KITTTITAS COUNTY COMMUNITY DEVELOPMENT SERVICES

Subject: Palomino Fields Div 2 (LPF-19-00003) Final Long Plat – Staff Review and Request for Additional Information

Surveyed by LMH Scale 1" = 300'
Drawn by Tml/FCS Sheet 1 of 5
Checked by FCS Project No. 18146

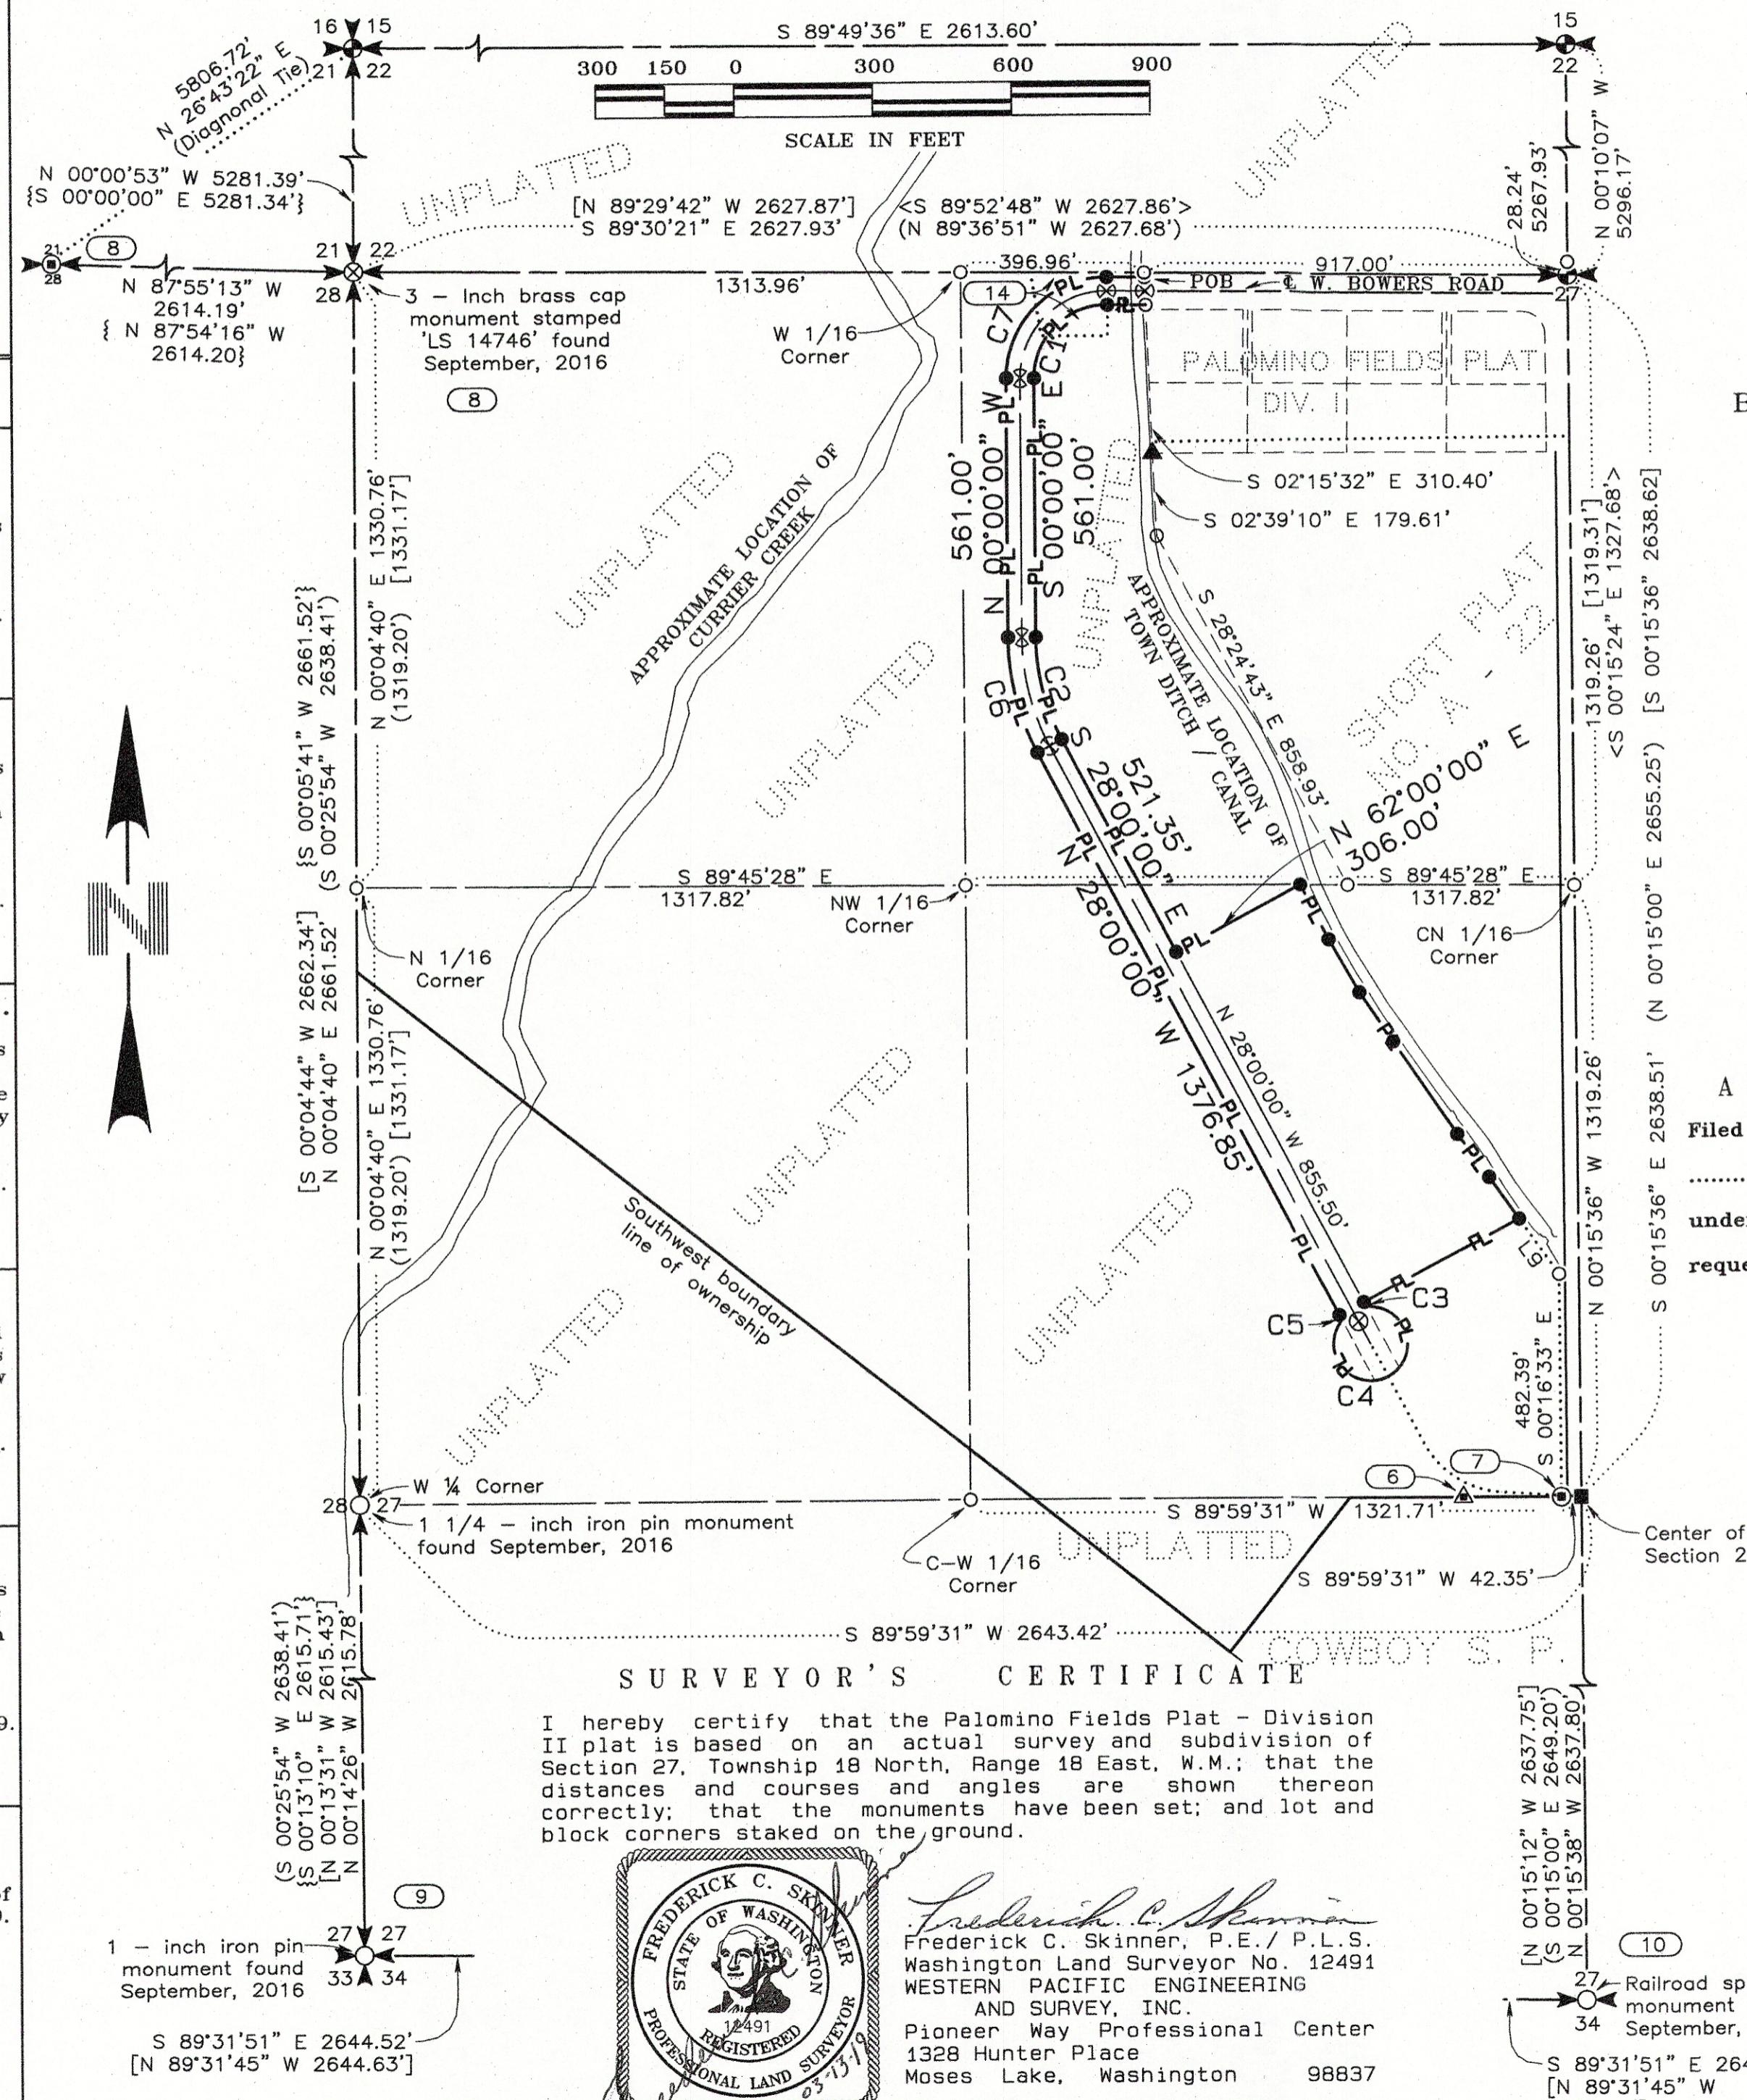
- An incorrect parcel number (471033) is listed in the Treasurer's and Assessor's signature box. This parcel was retired. The correct number is 491033.
- Parcels 11801 & 11802 should be listed in the Treasurer's box as well as the Assessor's box.
